From: Sue Howell
Sent: 10 July 2019 16:59
To: Neil Crowther <Neil.Crowther@arun.gov.uk>
Cc: Simon Davis <Simon.Davis@arun.gov.uk>
Subject: RE: Planning Consultation on: AL/33/19/RES

I would now **recommend no objection to the landscape detail** submitted in this reserved matters application AL/33/19/RES following consent on AL/8/16/OUT.

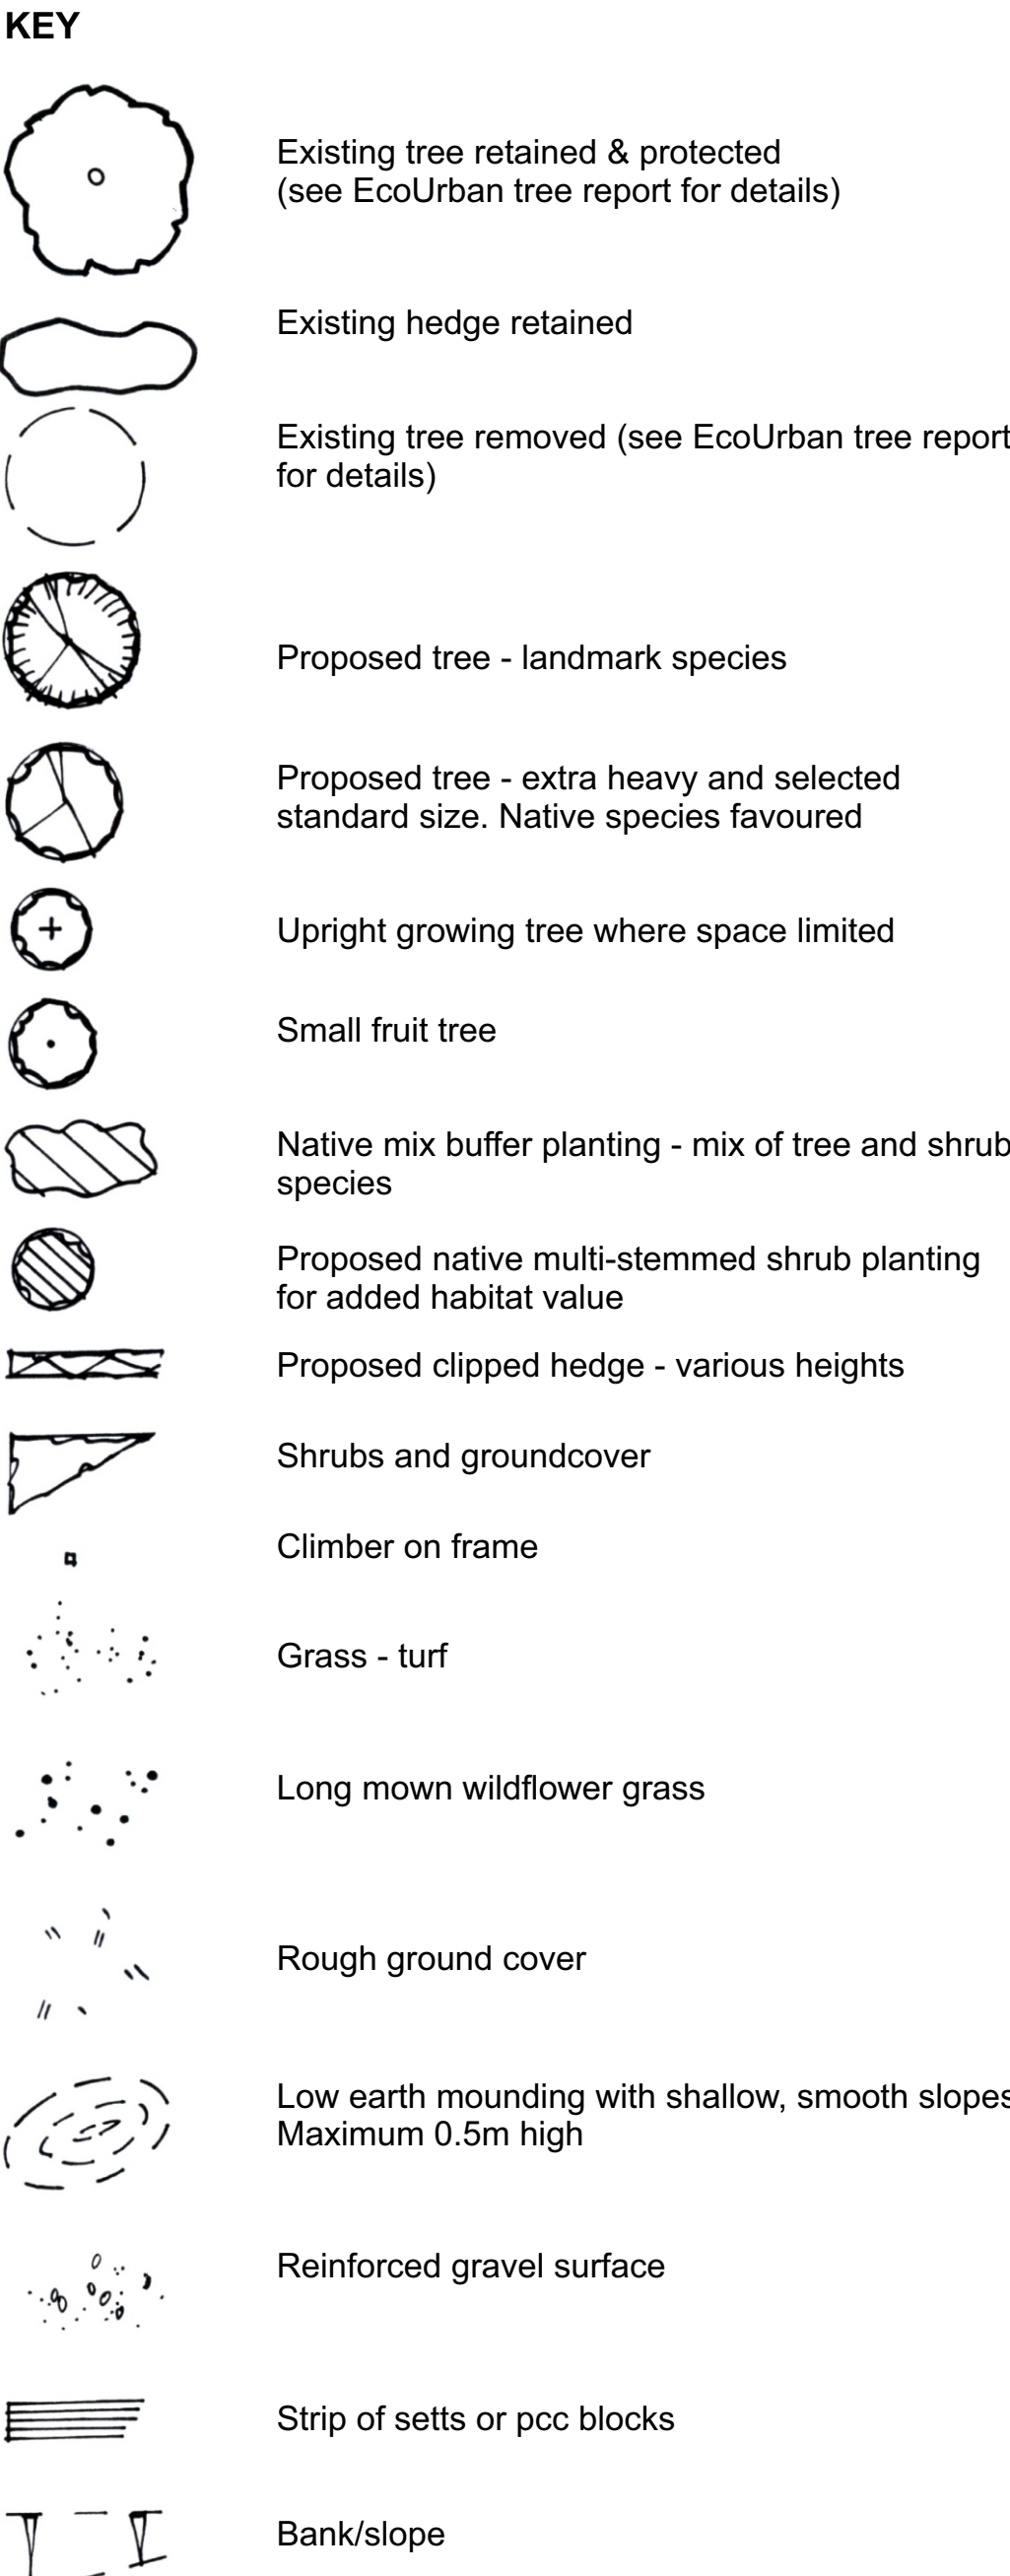
Further to the submission of the revised Planting Plan Dwg 2518-0102 July 2019 I can confirm that the information now submitted is comprehensive and details a landscape scheme which includes species choice, actual quantities, planting densities and size at time of planting. The proposals appear suitable for location having a varied and appropriate mix with a good palate of both evergreen and deciduous trees and shrubs. The proposed scheme has been specified to a size that is sufficient in height to provide instant impact whilst an appropriate size to promote establishment.
